Fort Street Public School – 1005 Upper Fort St, Millers Point NSW - SSD 10340

Thank you for your correspondence of 2 April 2020 inviting comments on an Environmental Impact Statement (EIS) for the State Significant Development (SSD) 10340 for the Fort St Public School Redevelopment, following the submission of the Secretary's Environmental Assessment Requirements (SEARS) on 28 June 2019.

ATTACHMENT A: Detailed Response

2 SECTION Site wide section - Fig Tree
1:200

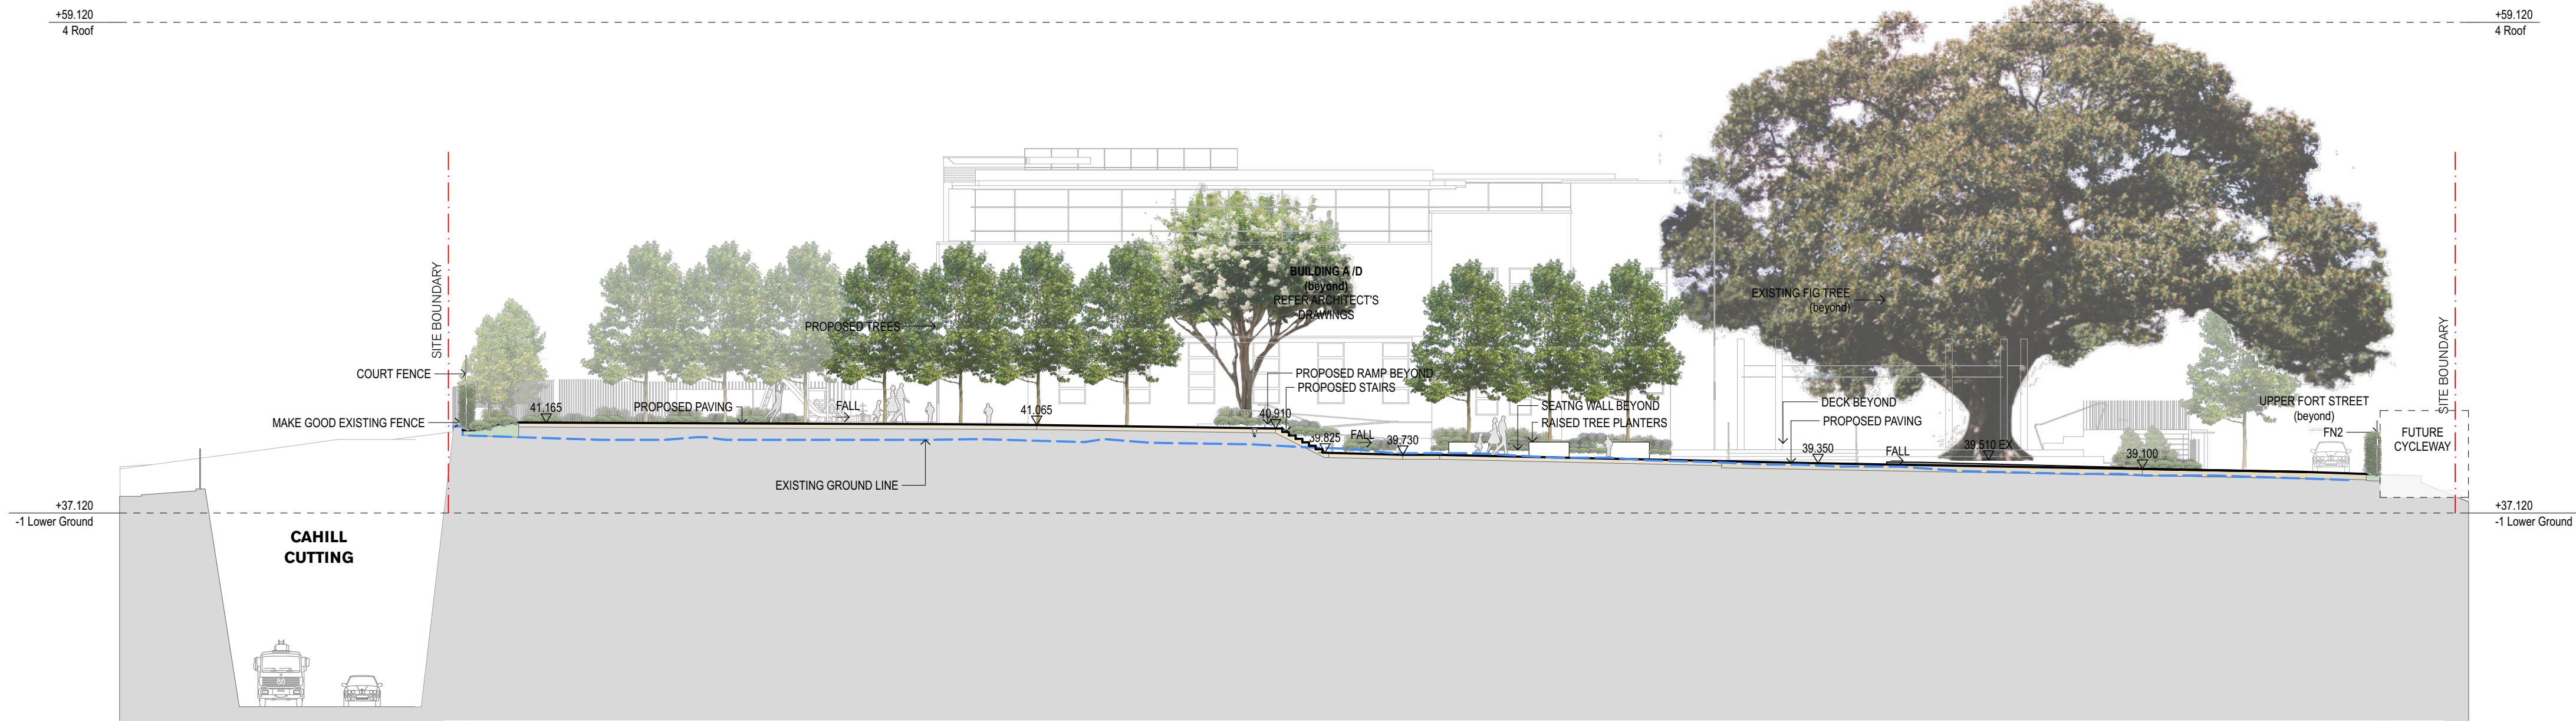
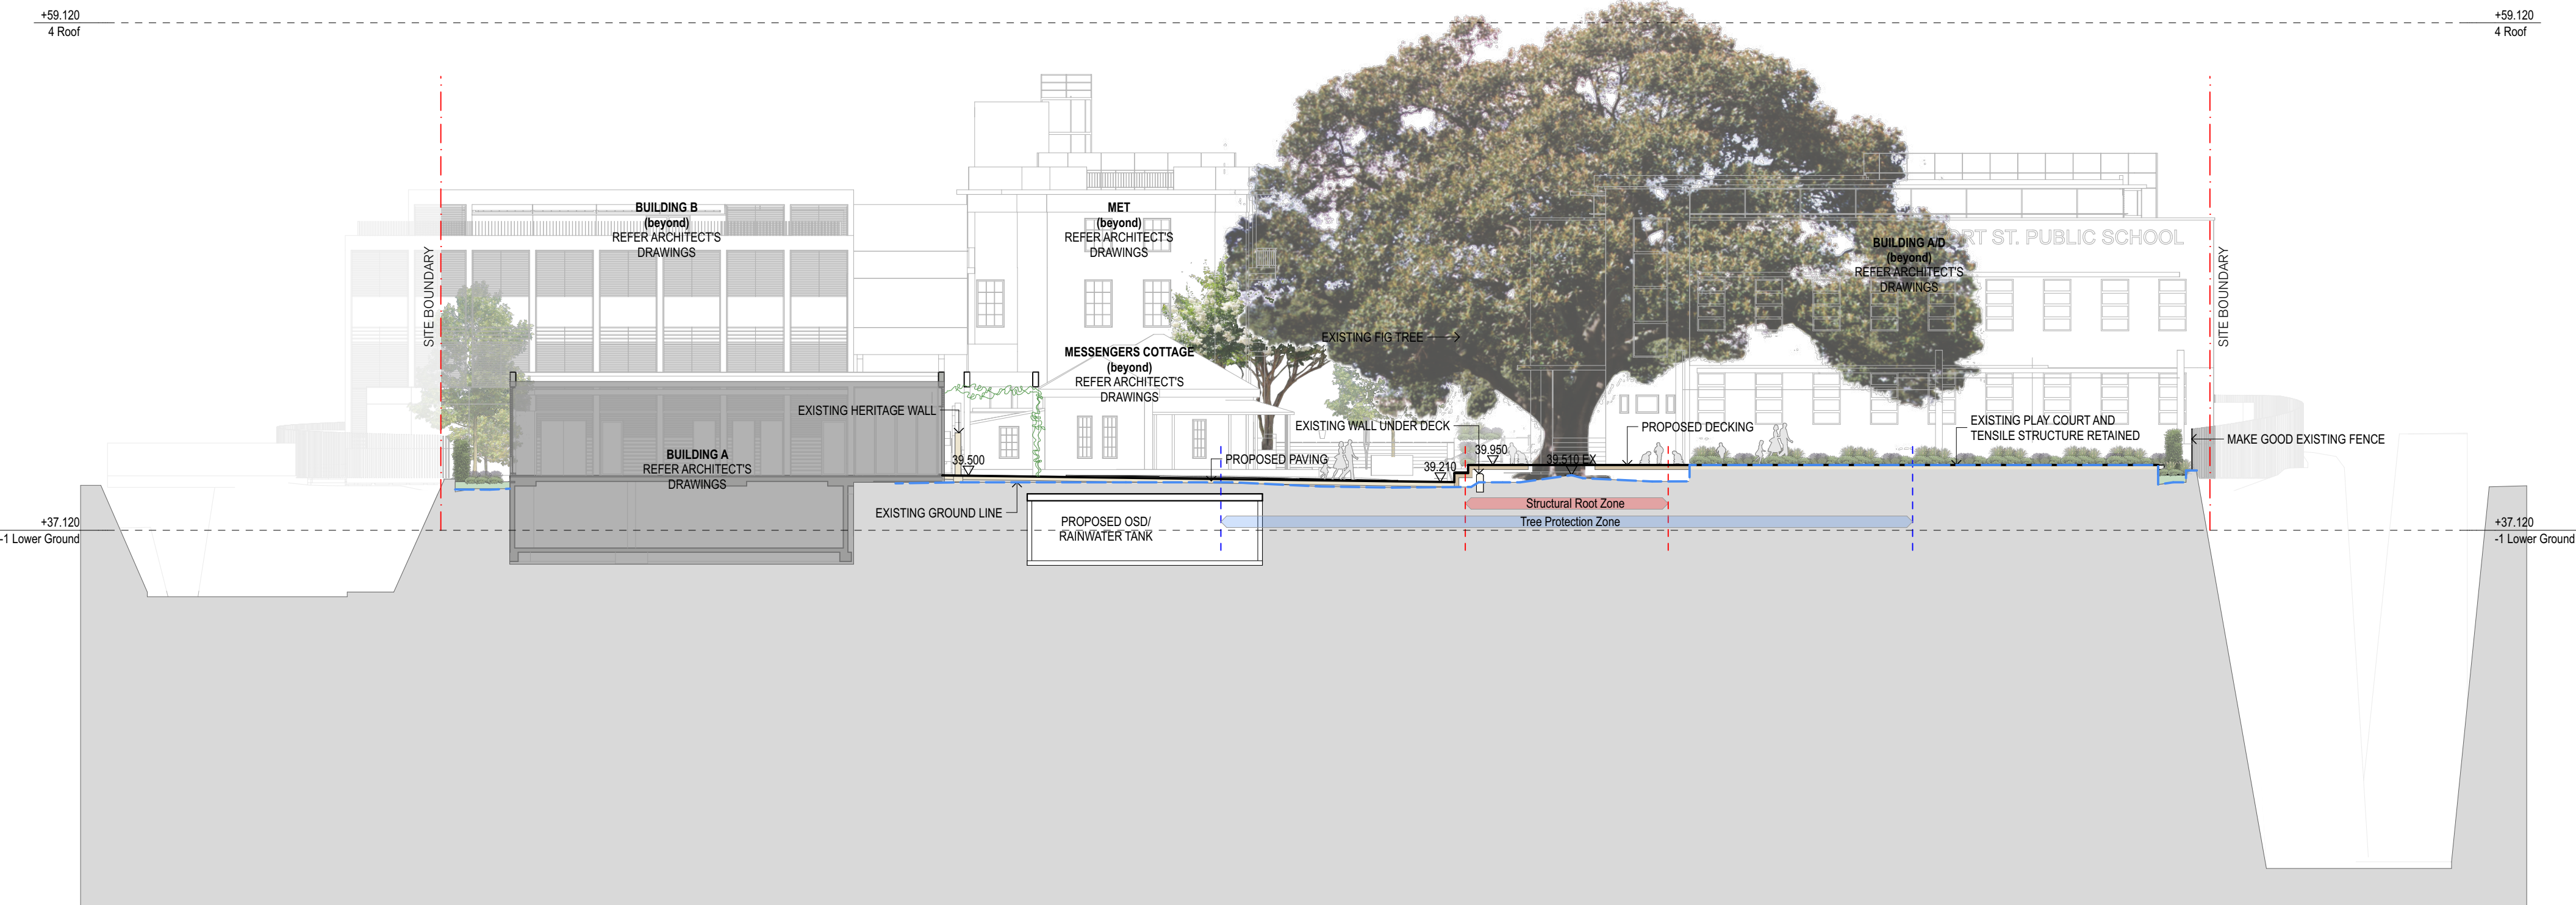
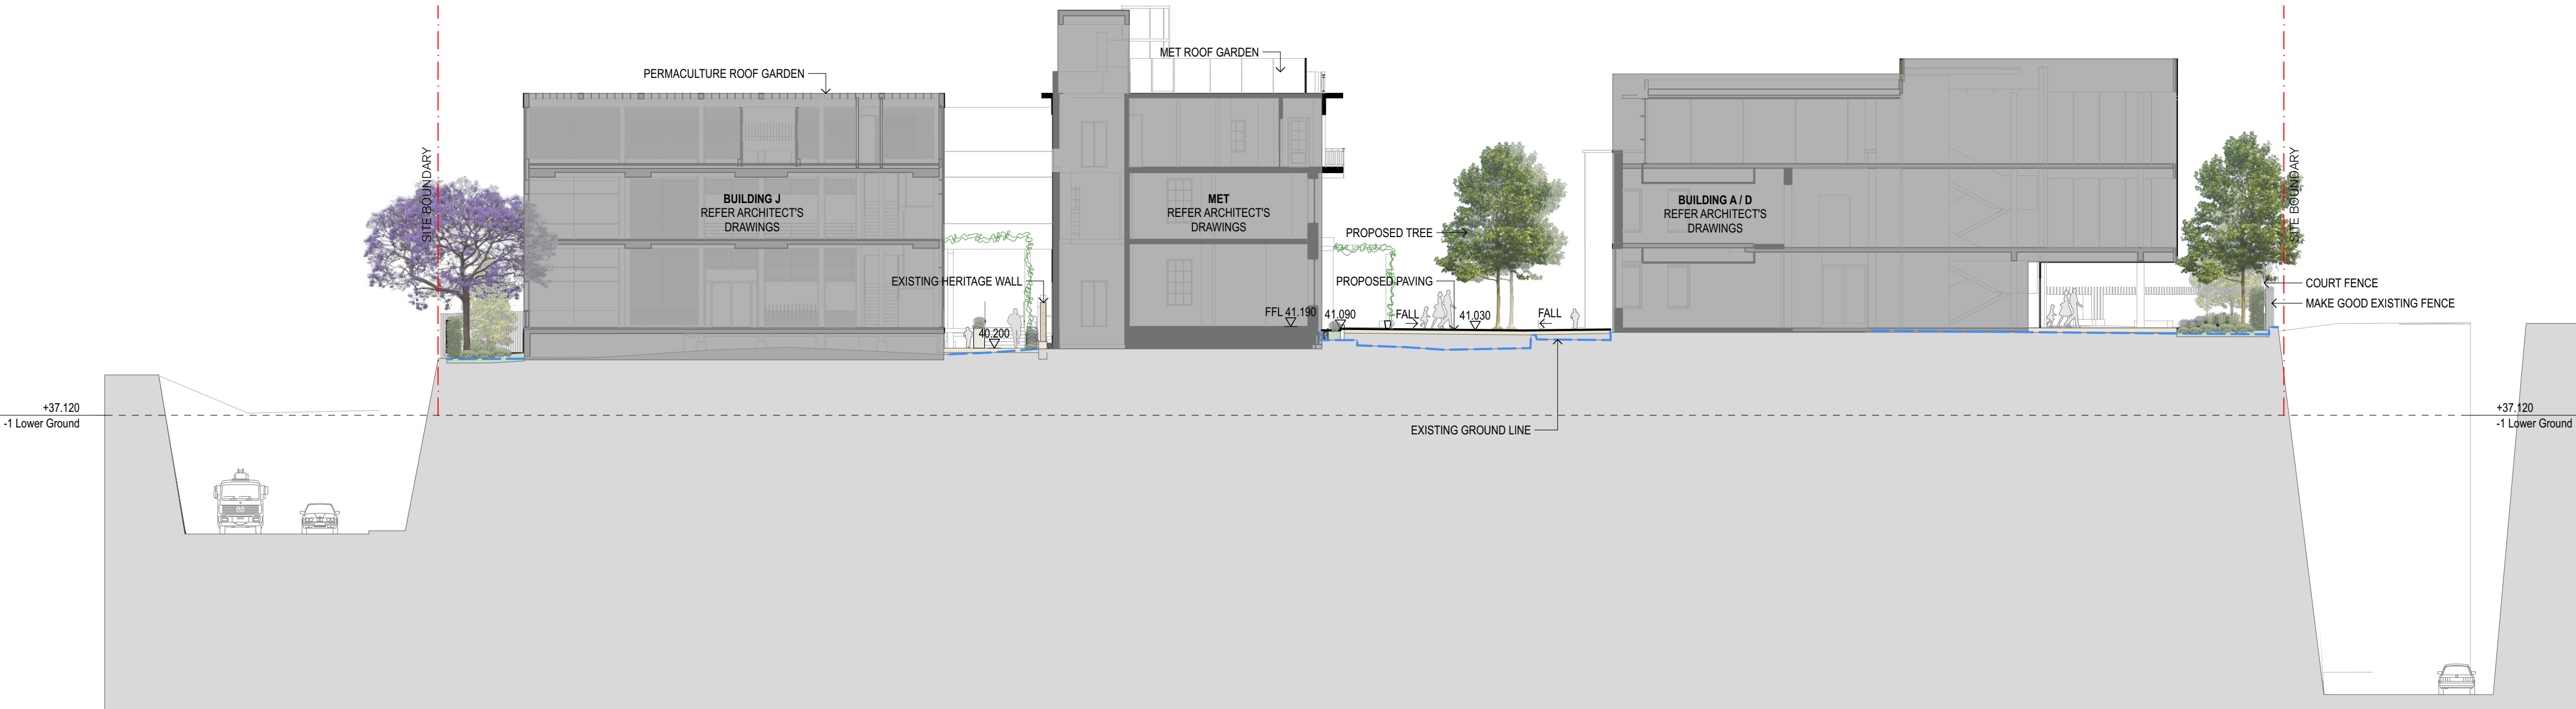
Street entrance, will impact the trees health. Section 2 in drawing number DA-8101 of the landscape section plans shows this paved area to be approximately half a metre from the Structural Root Zone (SRZ) of this tree.

- The proposal also includes the installation of a timber deck that encompasses the tree including the SRZ this has the potential to affect the trees health and structural integrity. It is recommended that the additional timber deck area surrounding Tree 1 is specified to be built using a flexible pier and above grade beam system to ensure protection of this significant tree.
